Our Ref: D2012/079437

**ENVIRONMENTAL ASSESSMENT NRE NO. 1 COLLIERY
PRELIMINARY WORKS PROJECT MODIFICATION MP 10_0046**

SUBMISSION BY SYDNEY CATCHMENT AUTHORITY

NRE No. 1 COLLIERY – PRELIMINARY WORKS PROJECT MODIFICATION

APPENDIX 2: PROJECT LAYOUT PLAN

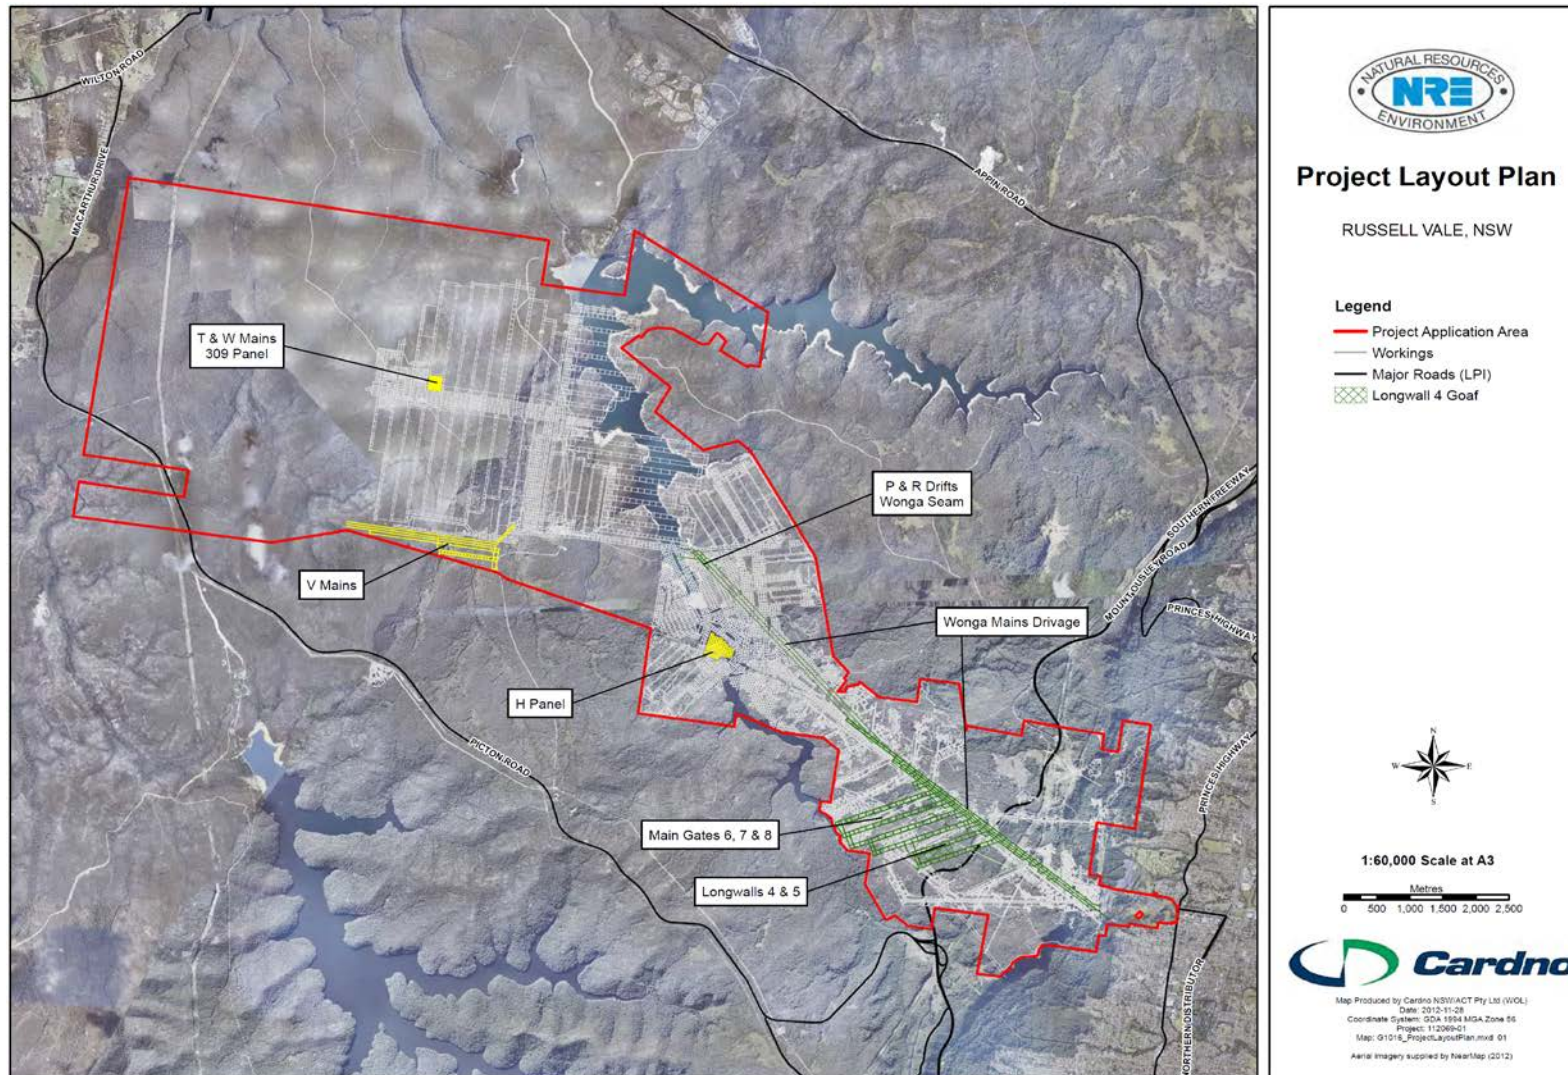
The SCA considers that it is appropriate for the first workings for longwalls 6, 7 and 8 to be assessed as part of the assessment of future secondary extraction as part of the Stage-2 Major Expansion Project. This would enable the entirety of the impacts of the longwalls to be assessed, and a more integrated approach to be taken to the management of impacts.

- *Longwalls 4 and 5* - this part of the Project has the potential to impact on the parts of Cataract River, Cataract Creek and associated upland swamps and catchments. All of these lands are owned by the SCA and are part of the SCA's Special Areas.
- *Maingates 6, 7 and 8 and future secondary extraction of longwalls 6, 7 and 8* – this part of the Project is located within the Cataract Dam Notification Area specified by the NSW Dams Safety Committee. Mining in these areas has the potential to impact on Cataract Dam, Cataract Reservoir, Cataract River, Cataract Creek and associated swamps and catchments. The dam, reservoir and all of the lands are owned by the SCA and are part of SCA's Special Areas.

- The modification EA provides revised predictions for vertical subsidence, tilt and strain for longwalls 4 and 5 that are within same range as in the draft EA for Stage-2 Major Expansion Project in the Wonga east. The modification EA does not provide revised estimates for subsidence, strains, tilts, valley closure and upsidence for Cataract River, Cataract Creek and upland swamps CCHS3 and CCHS4. The SCA acknowledges that the longwall 4 has been significantly shortened and excludes mining under a dyke and Corrimal Fault, and is therefore less likely to have a significant impact on the surface environmental features as long as "pillar run" risk is as predicted. However, the subsidence predictions for longwall 5 have not considered the presence of dykes and faults in the application area. The modification EA in fact states that as a result of ongoing operational and geological investigations, faulting and other geological matters may result in further shortening of longwall 5.

- revision to the subsidence predictions for longwall 5 which should include impacts of faults and dykes in the application area and appropriate setbacks from Cataract Creek and Cataract River to ensure the SCA's performance criteria for the Cataract River, Cataract Creek and associated upland swamps and catchment can be met
- revision to the groundwater modelling and groundwater assessment should be based on adequate and scientifically rigorous baseline monitoring data including consideration of the integrity of the Bald Hill Claystone
- revision to the impacts of subsidence on streams and swamps should be based on revised subsidence predictions and adequate baseline monitoring data, and
- revision to the ecological assessment should be based on revised subsidence, groundwater and surface water assessment.
